## The Millbrook Power (Gas Fired Power Station) Order

### Responses to the Examining Authority Written Questions – Submitted at Deadline 2

**Applicant's response to Examining Authority's First Round of Written Questions**

**Deadline 2: 17<sup>th</sup> April 2018**

September 2017	Drawing Number	Revision
A3 Scale	NTS	A
Drawn by	KIM	FIGURE 12.2 31116/3010/002
Checked by	JPH

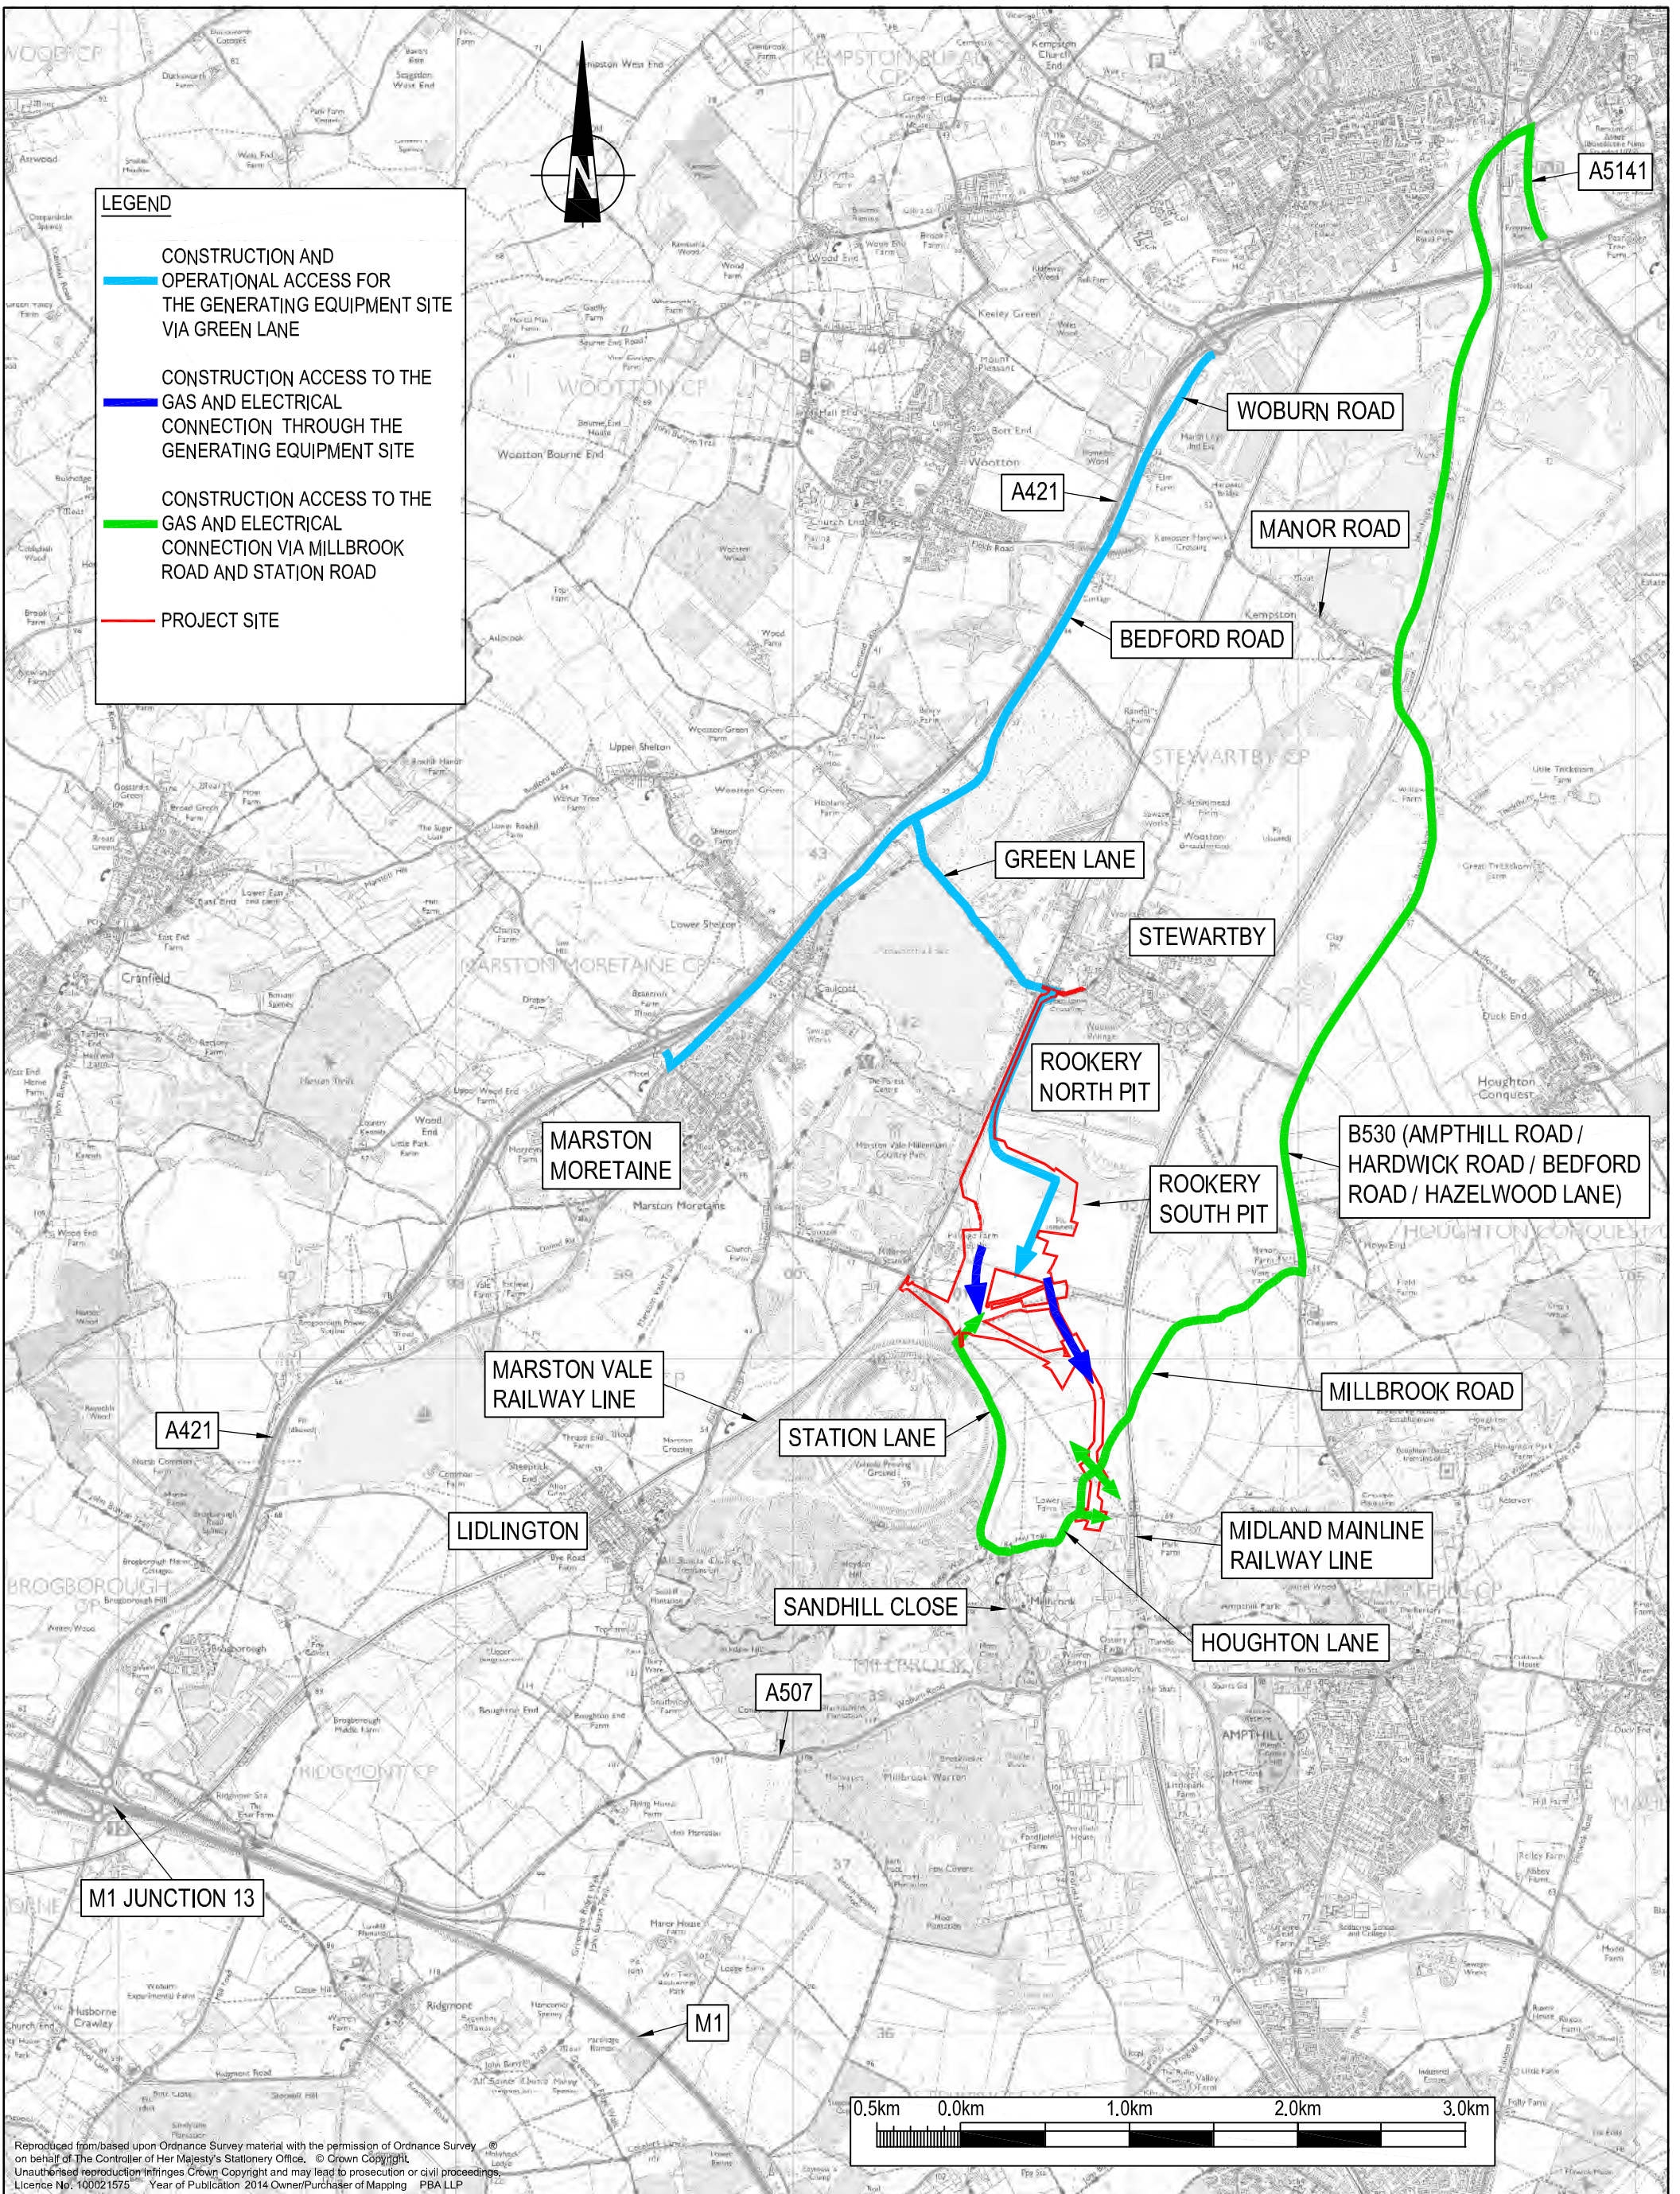
1.0.8	Applicant	ES paragraph 3.1.13 refers to road access to the site being shown on Figure 1.2 and paragraph 3.2.15 refers to a temporary construction laydown area. Figure 1.2 does not show either of these elements. Please confirm whether the access routes listed here are those shown in Figure 12.2 and the laydown areas are as shown in Figure 3.1 or provide further figures showing the details.
-------	-----------	---

- 1.1.40 Figure 1.2 of the ES [APP-049] shows the road network in the immediate vicinity of the Project Site, as well as clearly showing the access point to the Project Site from Green Lane, which was the intention of paragraph 3.1.13 of the ES. However, Figure 12.2 [APP-049] shows this in more detail, as well as highlighting the access points to the Project Site from Green Lane, Station Lane and Houghton Lane.
- 1.1.41 Although the temporary laydown area is shown on Figure 1.2, it is acknowledged that this is not clearly defined or labelled. The text in paragraph 3.2.15 is, however, referring to the laydown area as shown on Figure 3.1 where it is defined and labelled.
